We are writing to strongly oppose the revised 2.4 noise mitigation plan, especially night flights.

Figure 12.9
Aircraft noise - night-time L_{ASmax}
contours - year of forecast maximum
capacity

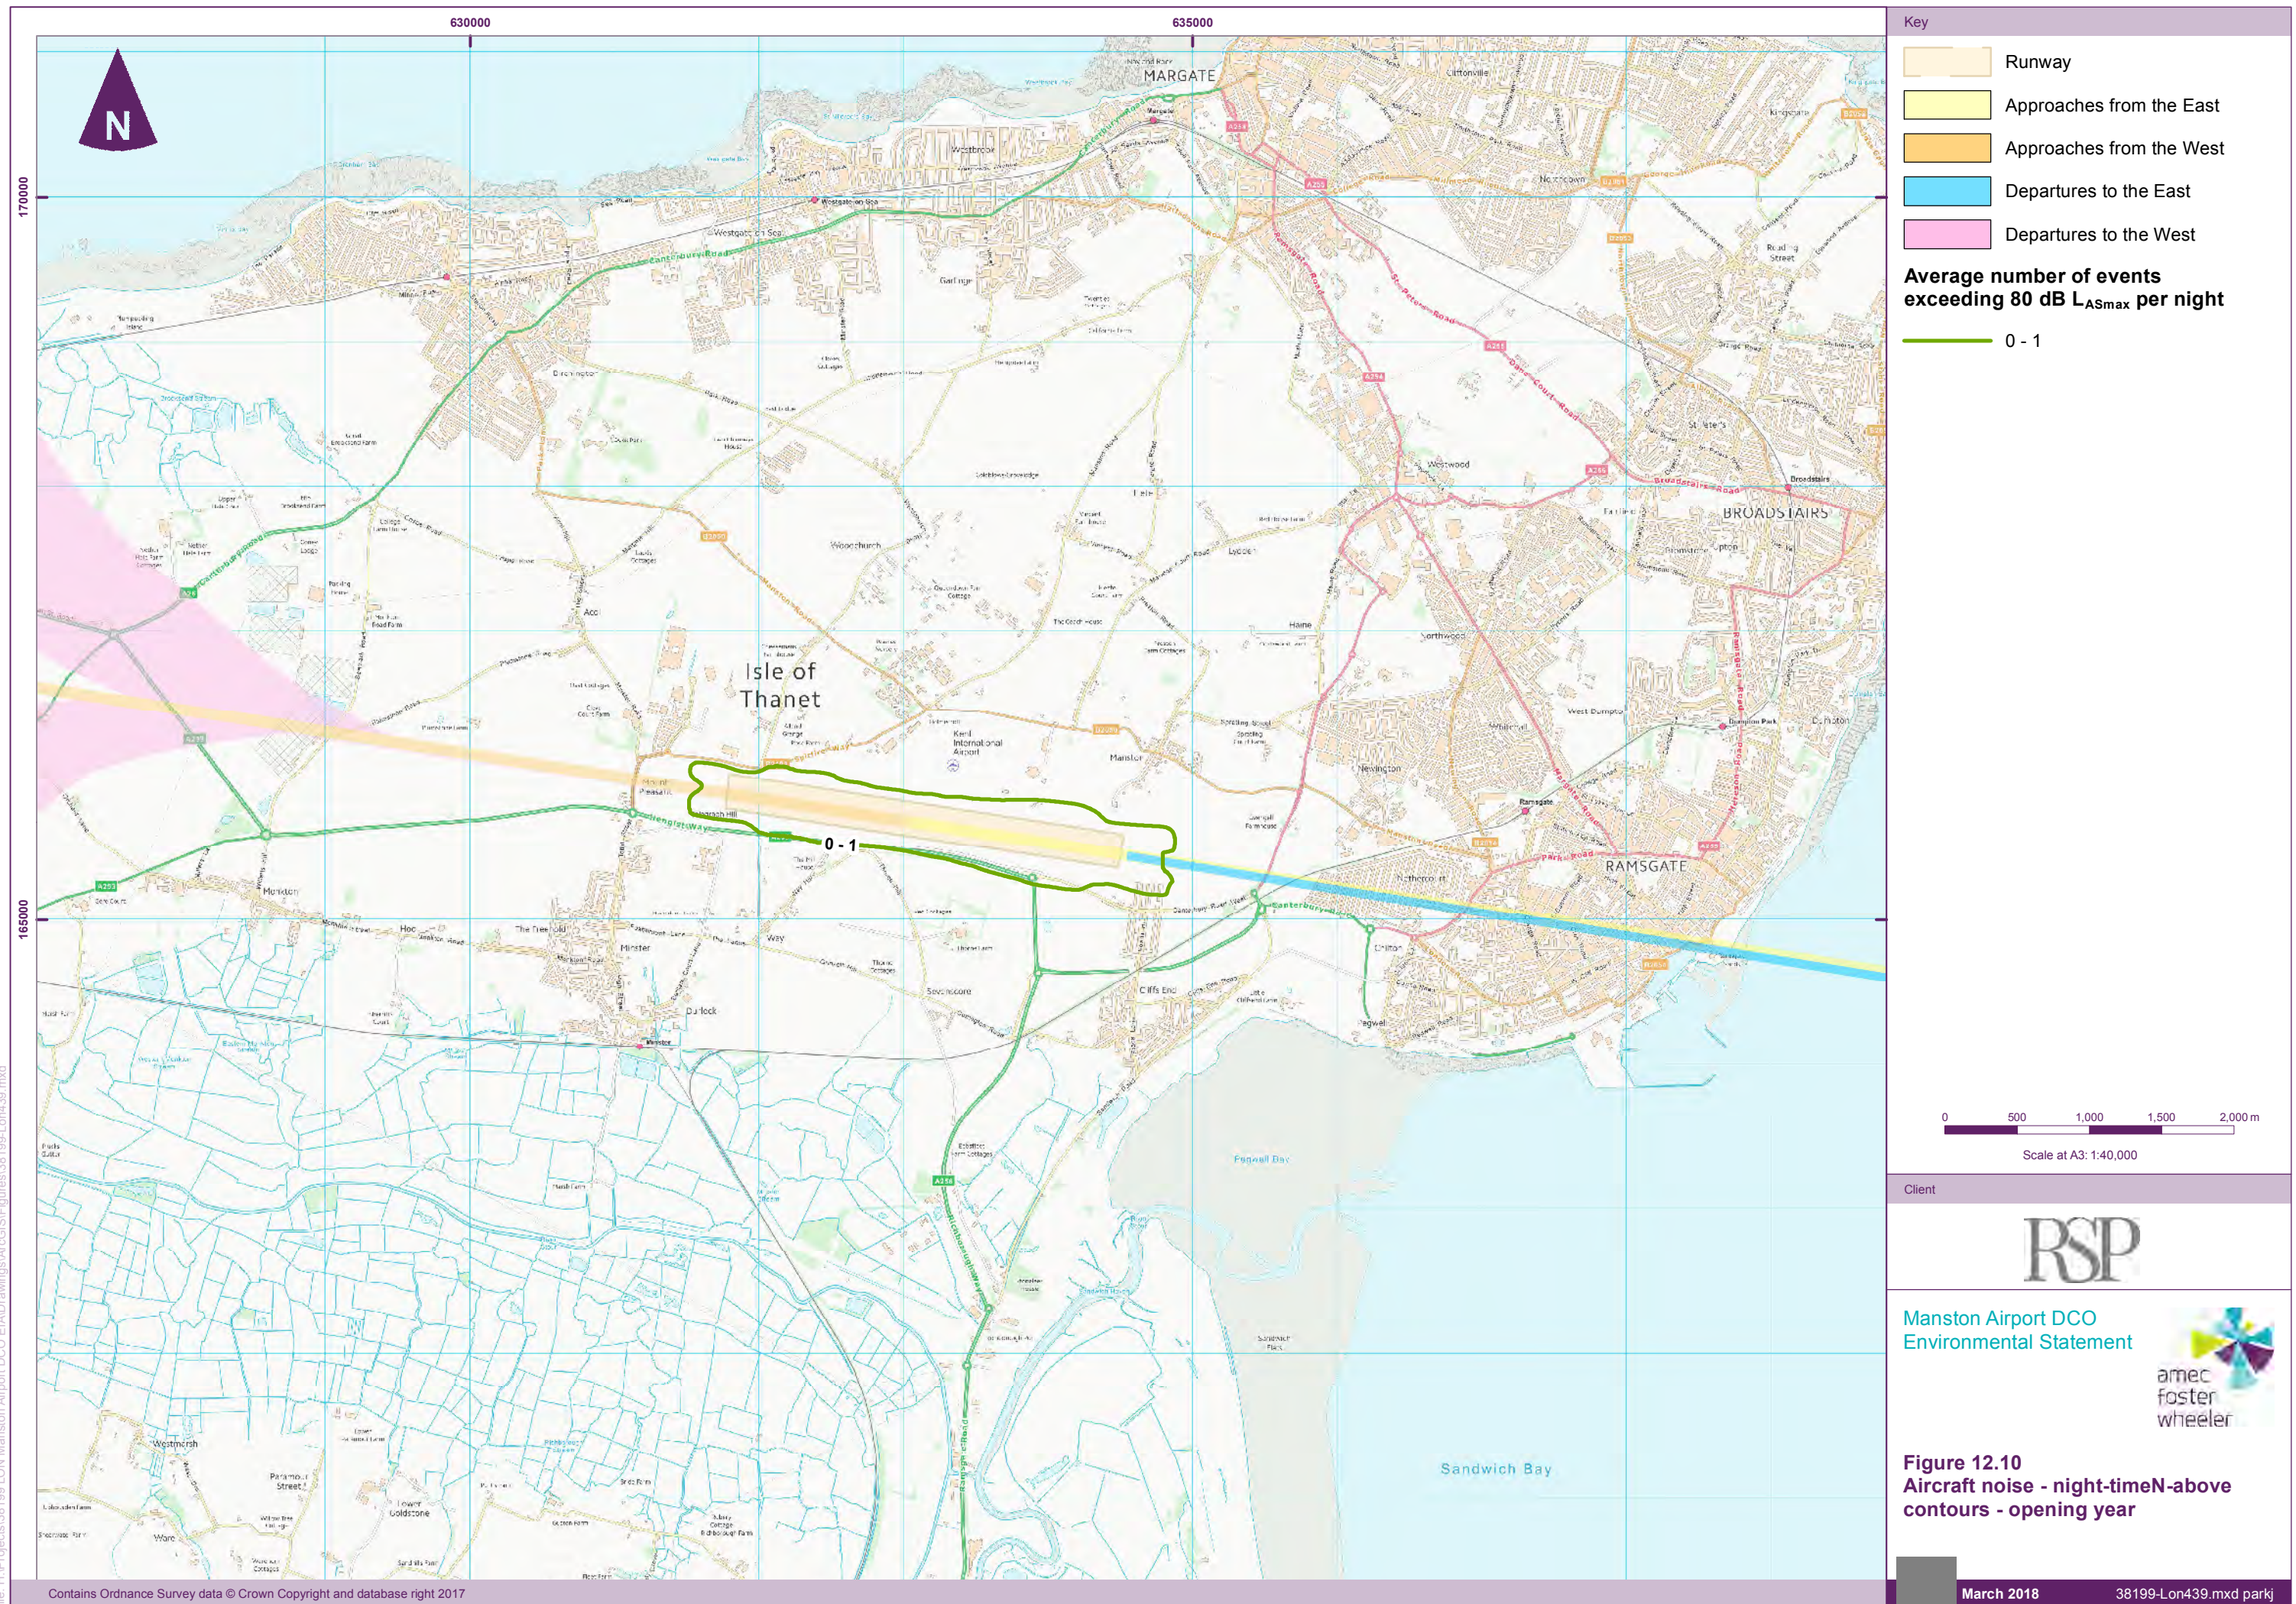
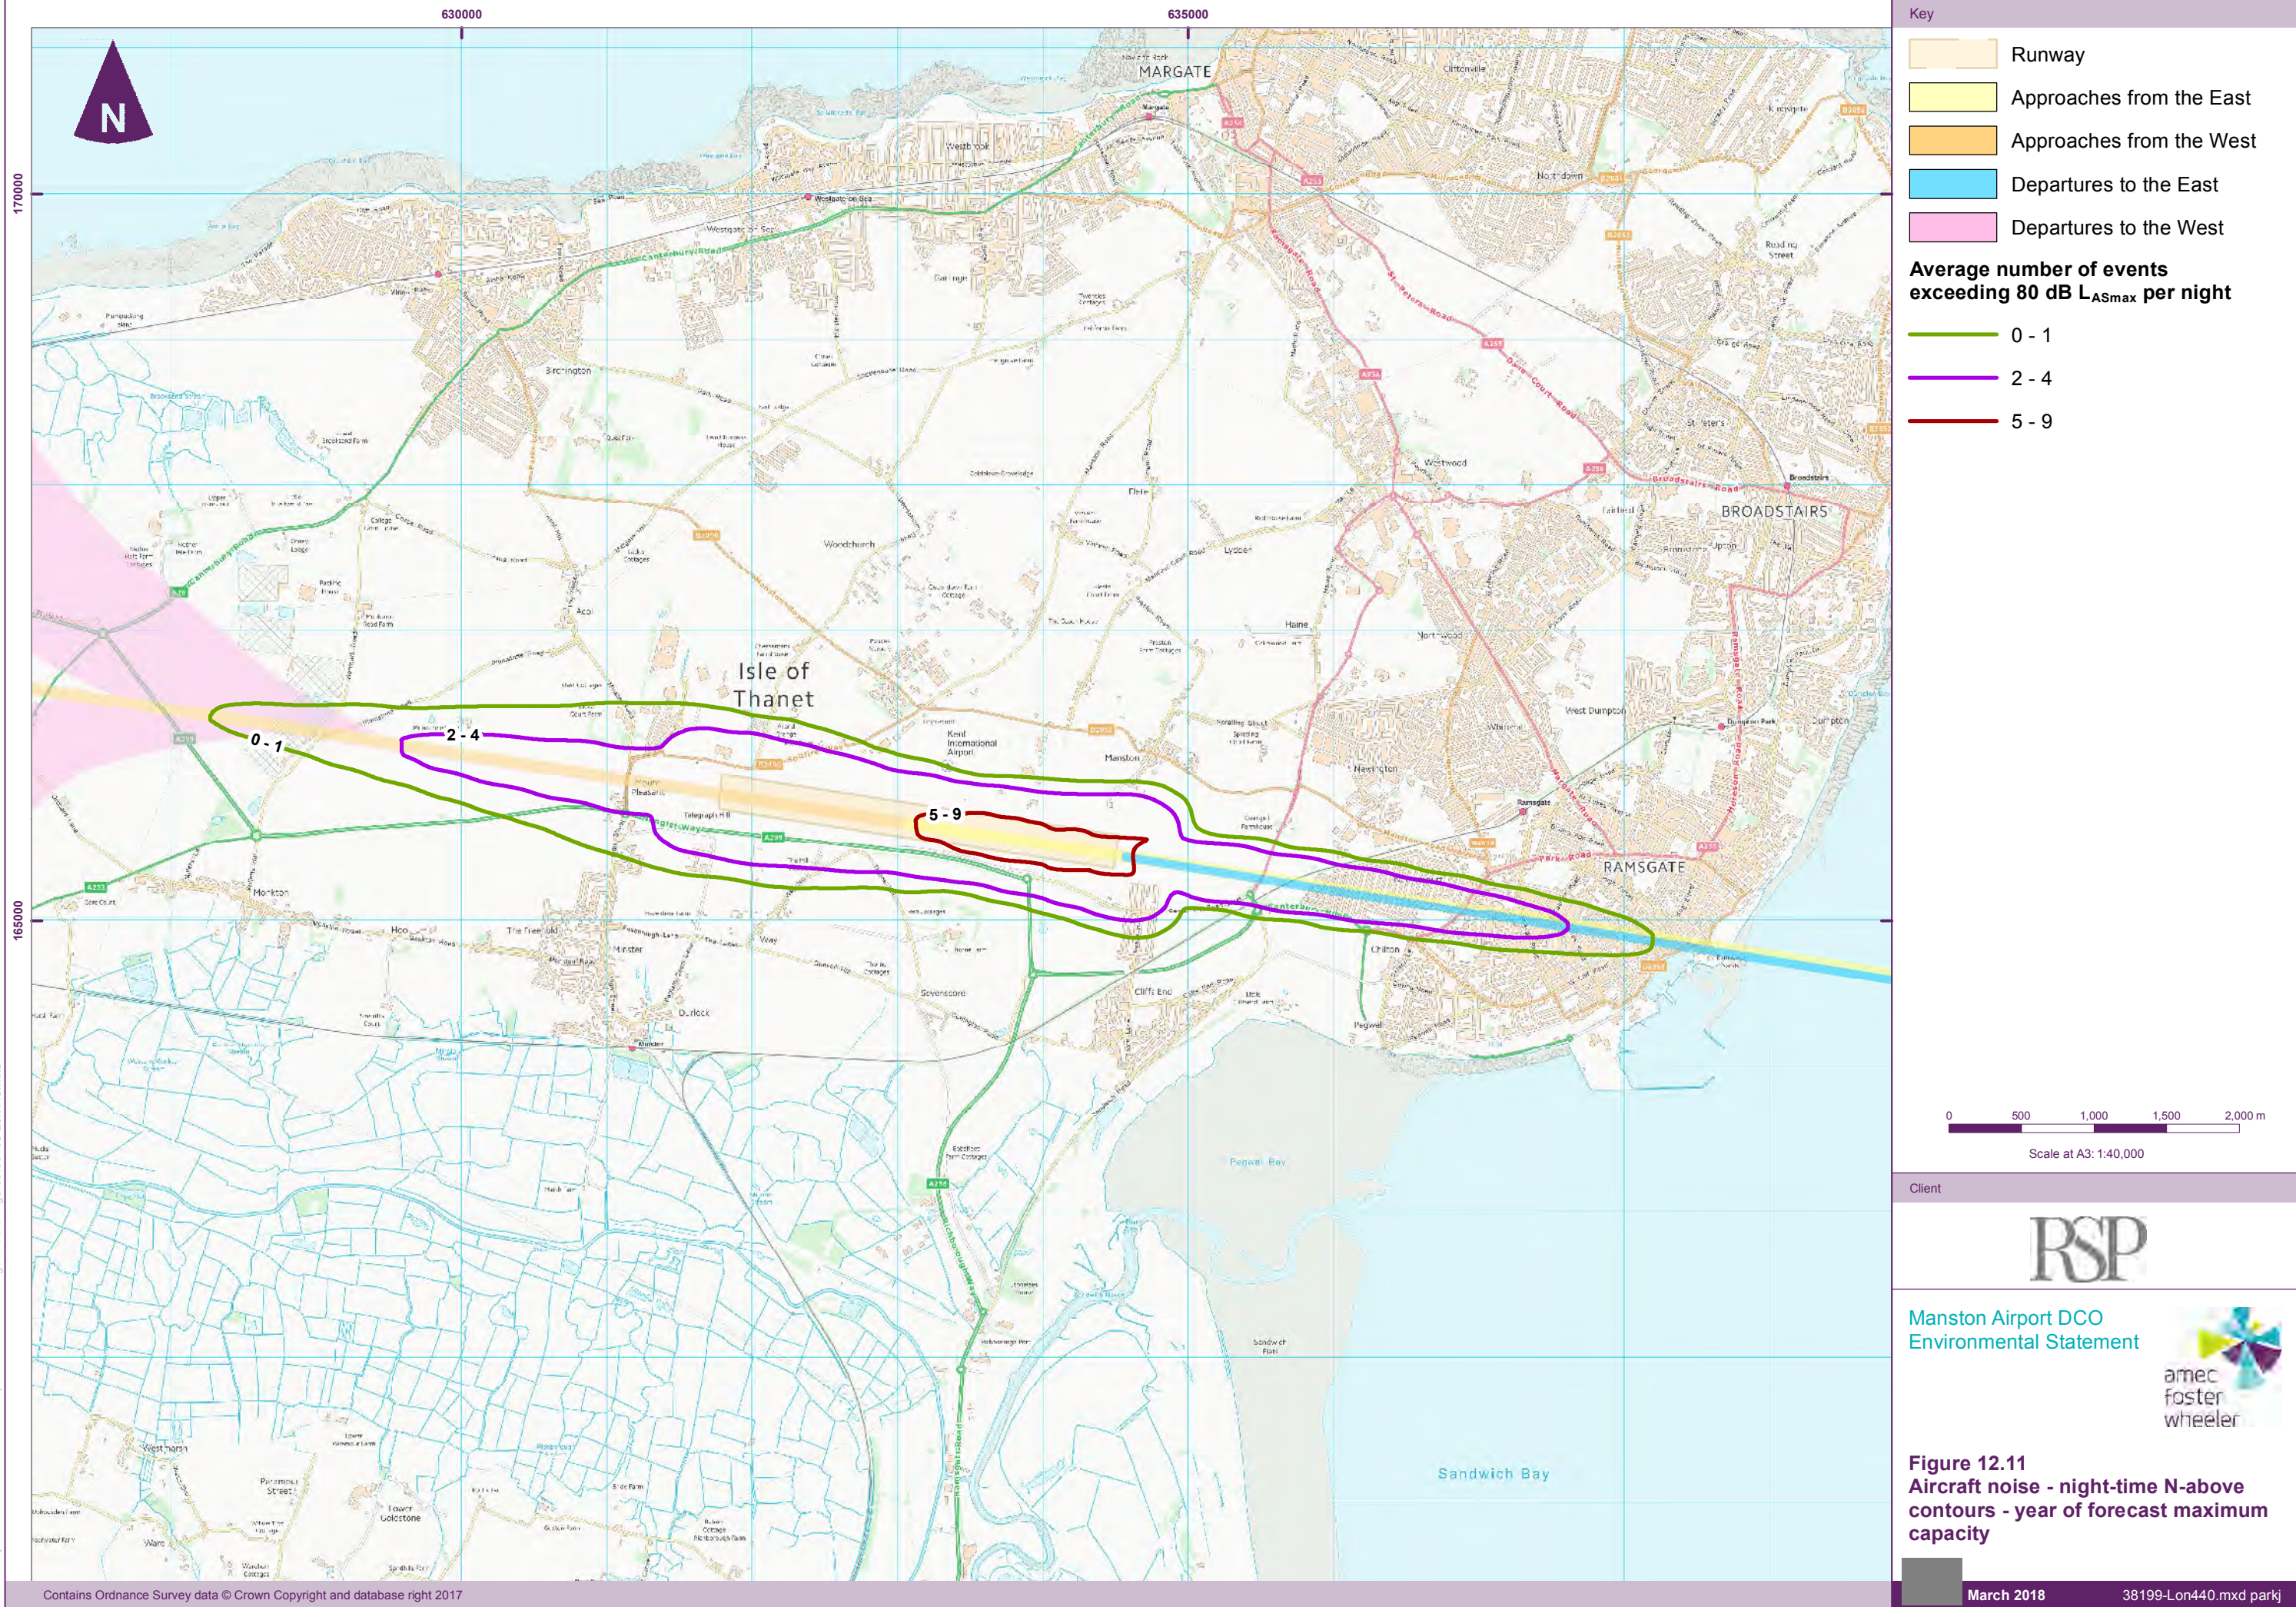
16.3 The operator of any flight departing between 0600 and 0700 aircraft that exceeds 82 dB LASmax at the relevant noise monitoring terminal will be subject to a penalty of £2000 and further penalties of £150 for each additional decibel exceeded above 82 dB LASmax.

Where are the noise caps for the airport? These appear to be entirely notational? Why will there only be 4 noise monitors 6.5km from start of roll on the departure paths only – none for arrivals and none in residential areas? Are RSP saying they will base the noise levels not on actual figures - no noise monitoring apart from those 4 monitors 6.5km away, but on hypothetical noise models? RSP must monitor the noise in residential areas under the flight paths and using actual noise monitors not forecasts or models.
